Consultation Response from KC Landscape
2026/90232 - New Mills, Brougham Road, Marsden, Huddersfield, HD7 6AZ
Redevelopment of mill complex of 11,584sqm for mixed use development, including building demolition, site clearance, site remediation works, the removal of buildings and floor slabs to open up the River Colne, repairs to retained buildings, conversion of lower ground floor of western mill to Class E (food and non-food retail, restaurant and cafe), new buildings providing light industrial / R&D uses (limited to Use Classes Eg(ii)(iii)), the alteration and repair of an office building (Use Class Eg(i)), the creation of a new public square and associated hard and soft landscaping, circulation and servicing space, car parking and ancillary structures
Date Responded: 01/06/2026
Responding Officer: KC Landscape
Responding Ref: QQ25

## Plaza - Detail Area

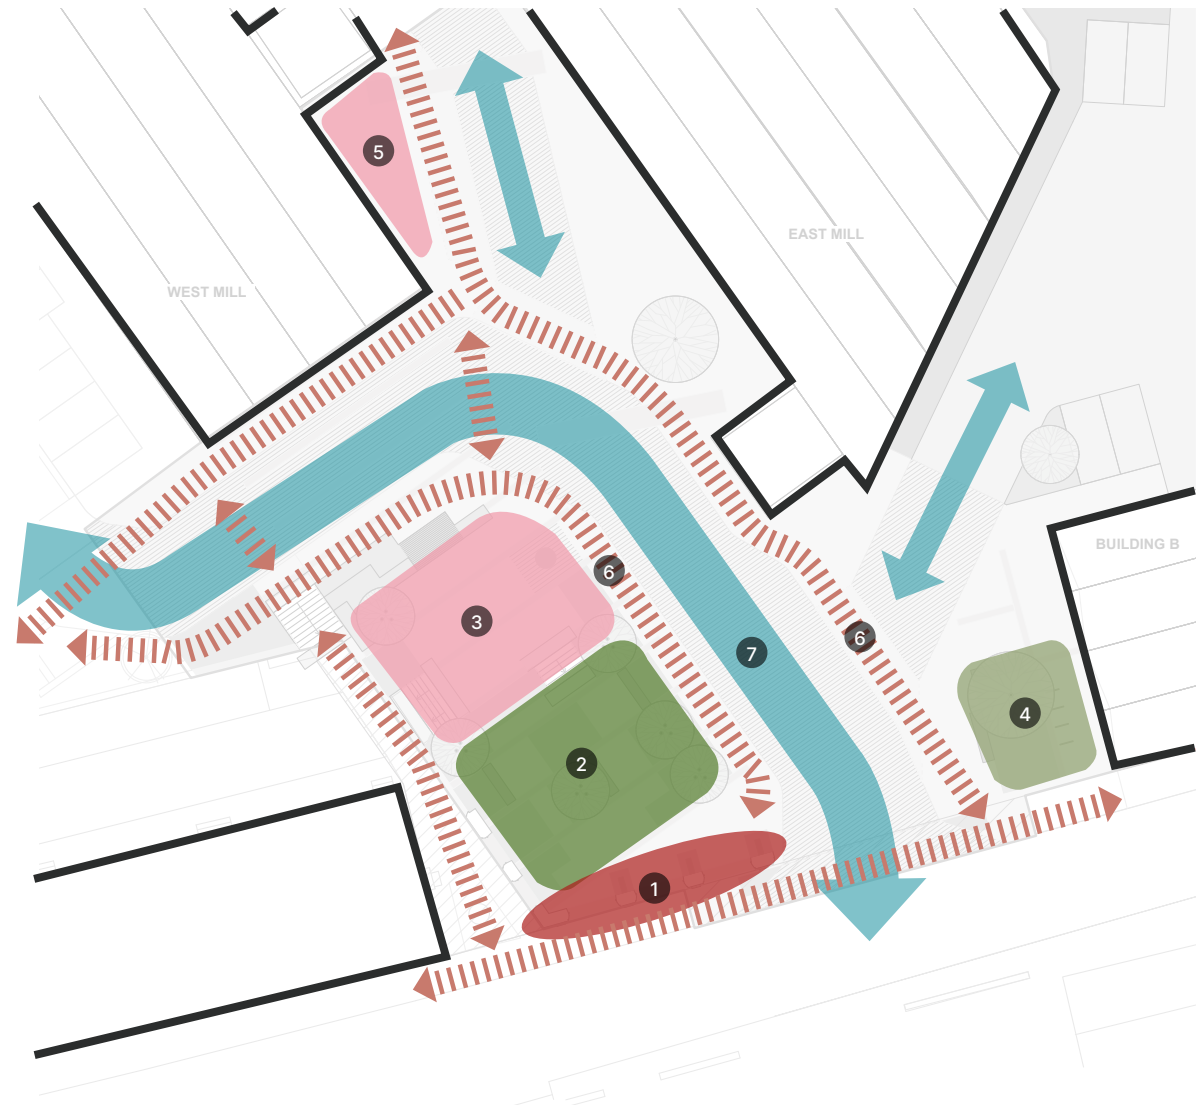
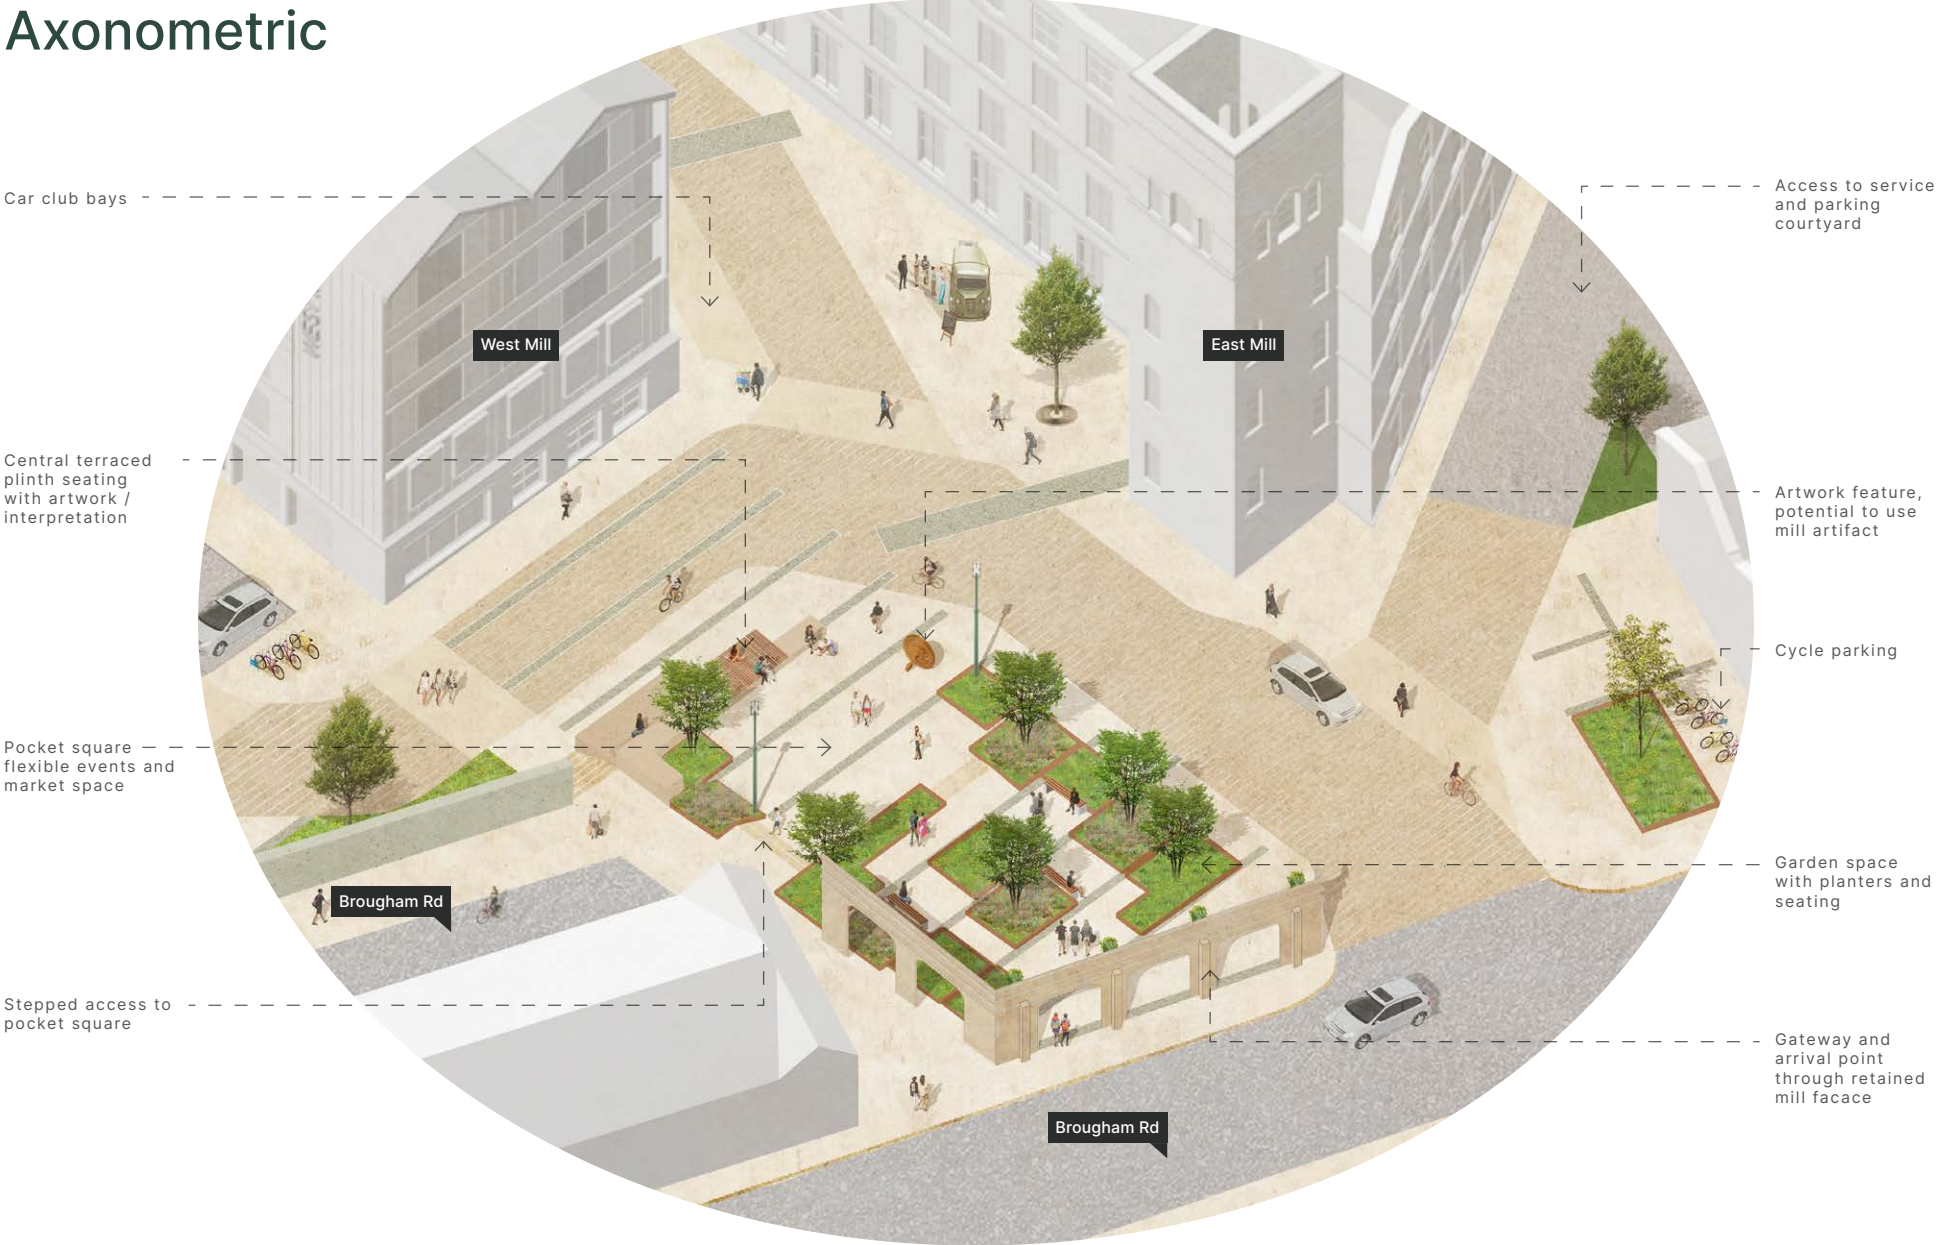
The retention of the wages office façade is welcome, however does this tie in sufficiently with the character of the public realm behind or is it tokenistic? This building is such a key feature on Brougham Road, the use of its façade as a key feature abutting or as an entrance to the public realm beyond needs to be authentic and have spatial integrity.

Given the entrance area 1 being of a very similar design and materiality to the Peace Garden in Manchester City Centre, the proposed design of the public realm scheme risks being generic in design.

We welcome the improved permeability and connectivity through the site, however, with this comes a clearer visibility of the vehicular areas. Marsden is very tight for parking, so we don't anticipate this being an empty car park very often. The relationship between the car park and landscaped public realm areas should be considered carefully as the car parking remains dominant in places and from certain views looking into the site (from the north and Warehouse Hill, this is screened by mill walls). Even where screened, they reduce quality of the public realm and weaken the riverside experience due to their visibility.
